Application by Springwell Energyfarm Limited: Springwell Solar Farm (Application Reference: EN010149)

Responses to Section 51 advice and Section 55 Checklist

DRAWING TITLE:
STREETS, RIGHTS OF WAY AND ACCESS PLANS
 SHEET 7 OF 15

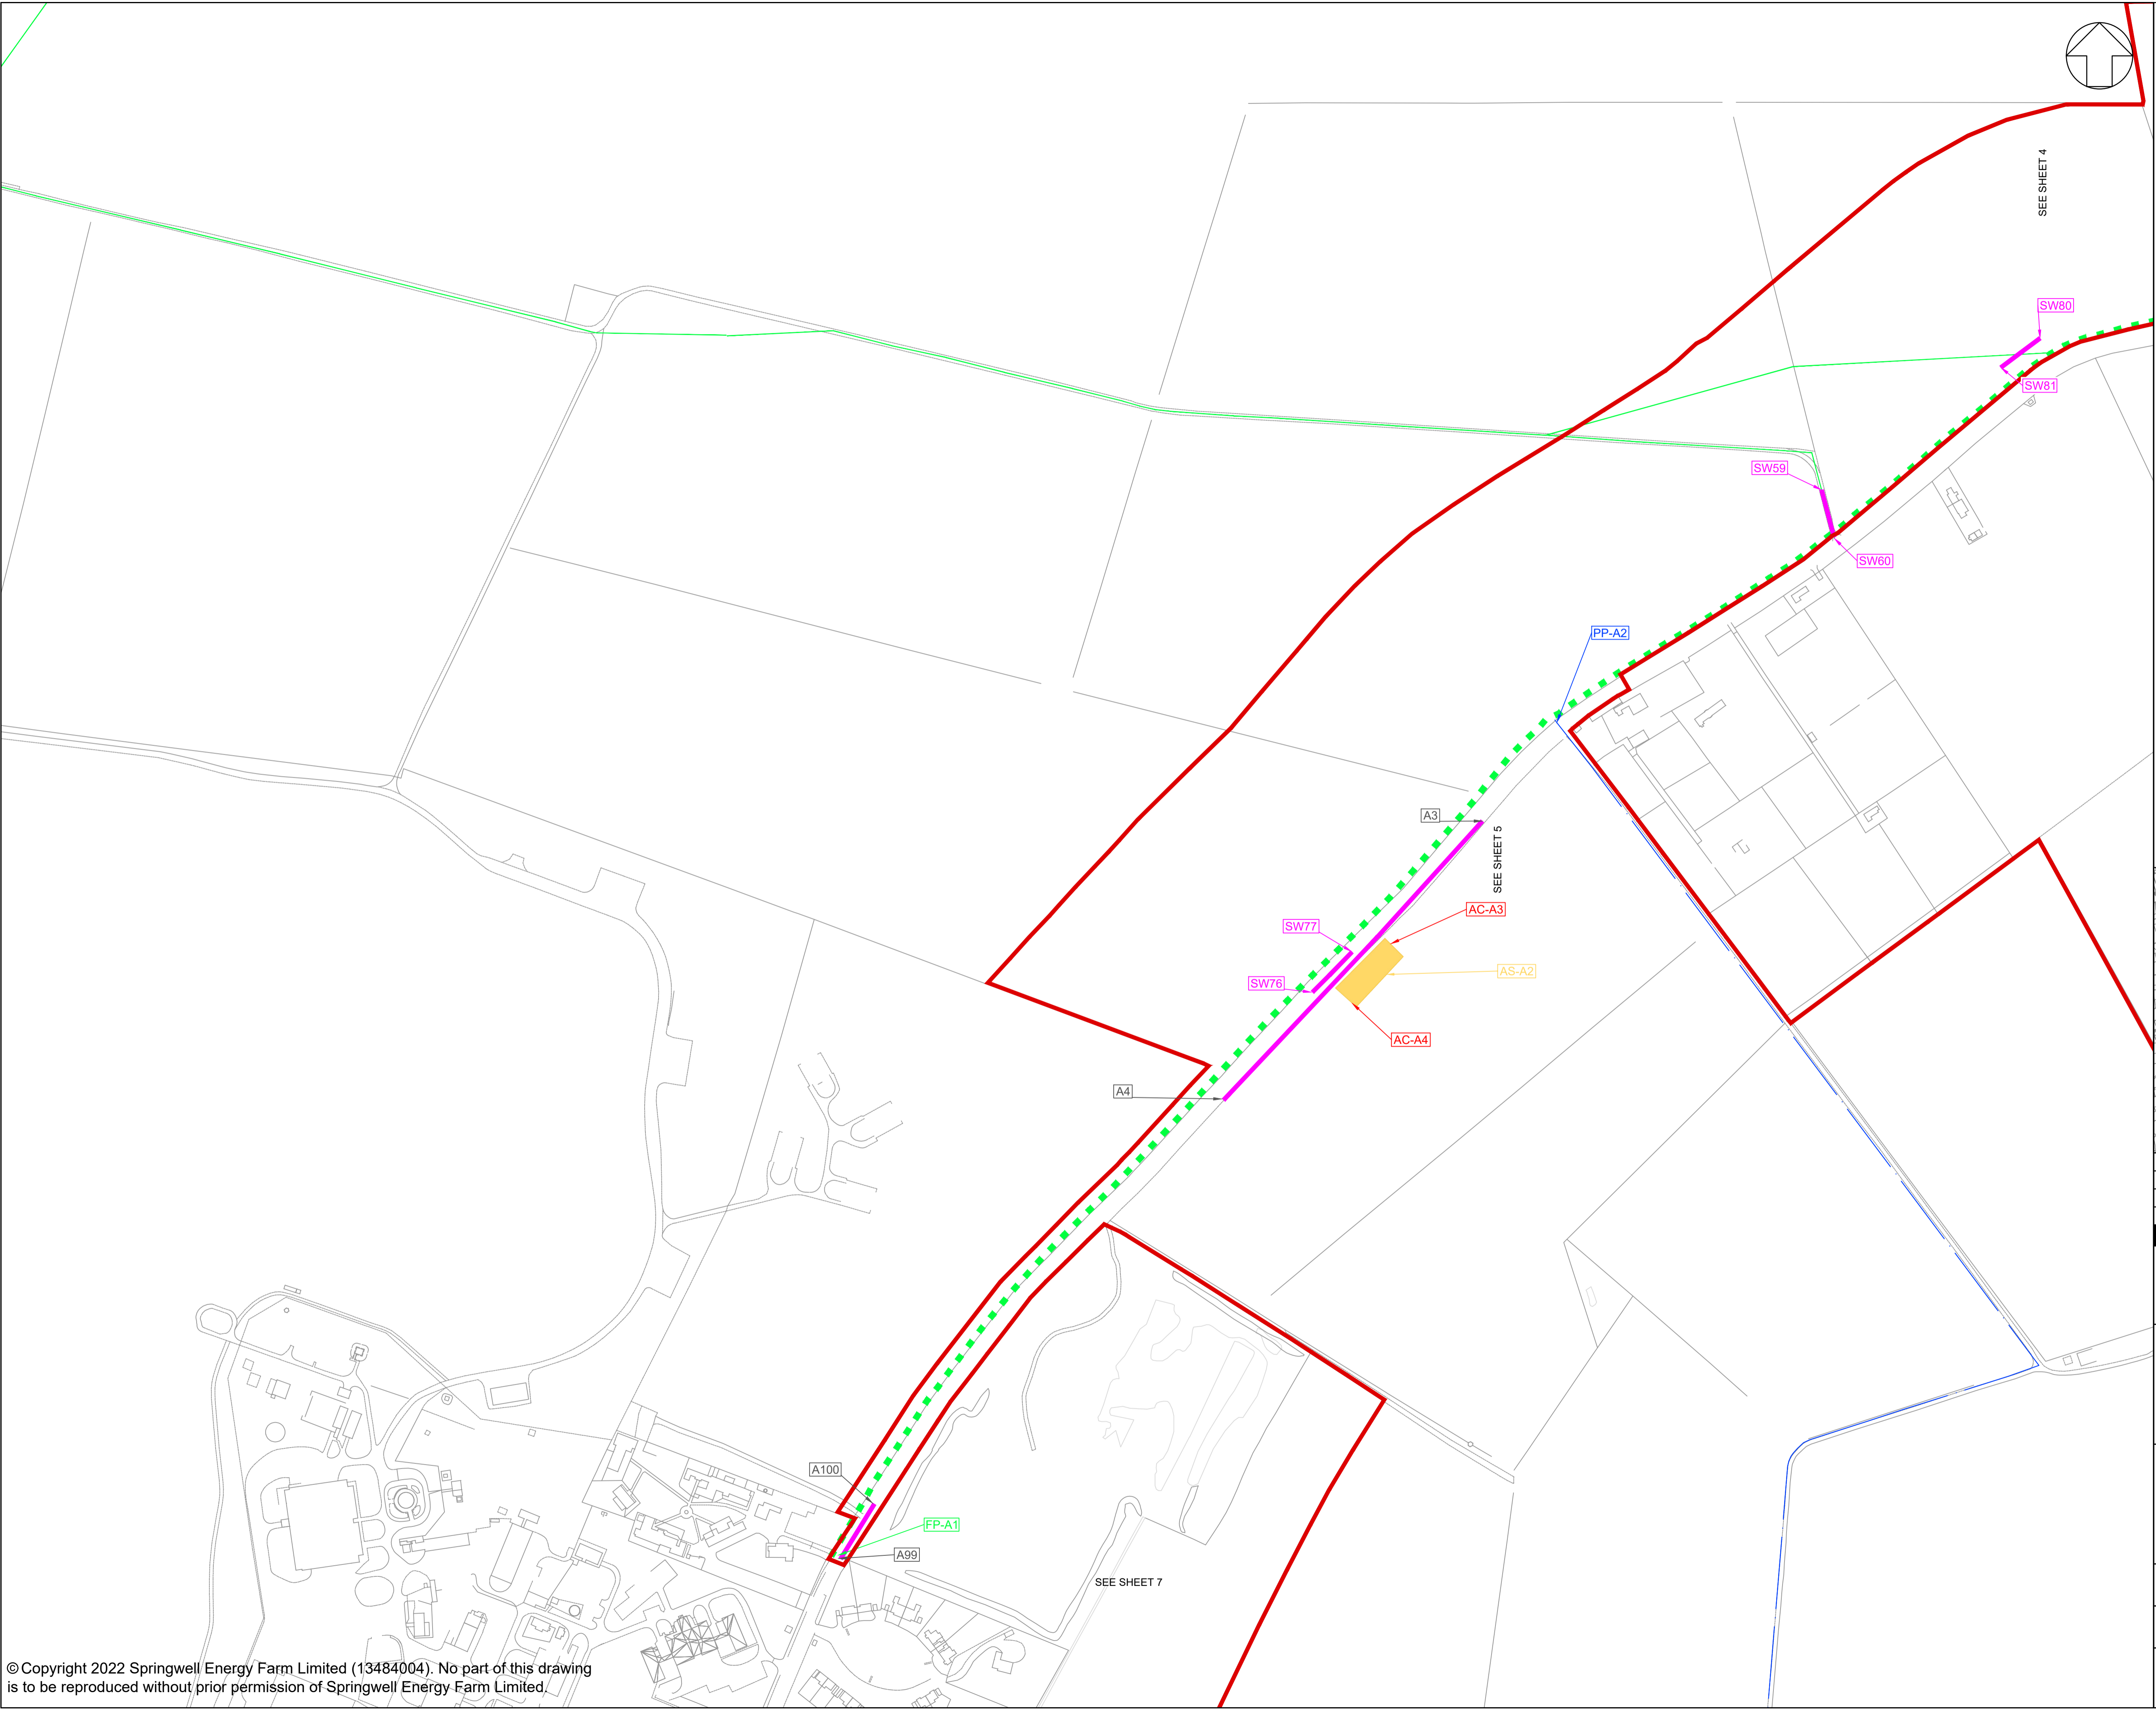
Document/topic	Section 51/55 Advice	Response	Revised Document Submitted
	listed in the Book of Reference. The Applicant is advised to review/amend accordingly.		
Location, Order Limits Grid Coordinate Plans (Doc Ref 2.1)	It is unclear if the inset showing B1191 (Heath Road) on sheet 7 of 15 is to the same scale as the rest of this sheet. The Applicant is advised to review/amend accordingly.	The inset is shown at the same scale as the rest of the drawing. The scale / scale bar shown the title block is correct and applicable to both the main drawing and the inset.	N/A
Streets, Rights of Way and Access Plans (Doc Ref 2.4)	Scale listed on the key plan (1:100m) is likely incorrect. A pink line is used for Street Works ('SW' Reference) and for Proposed Alterations to Streets ('A' Reference). This could cause some confusion for stakeholders. The Applicant is advised to review/amend accordingly.	The Streets, Rights of Way and Access Plans have been updated to make this distinction clearer.	Streets, Rights of Way and Access Plans
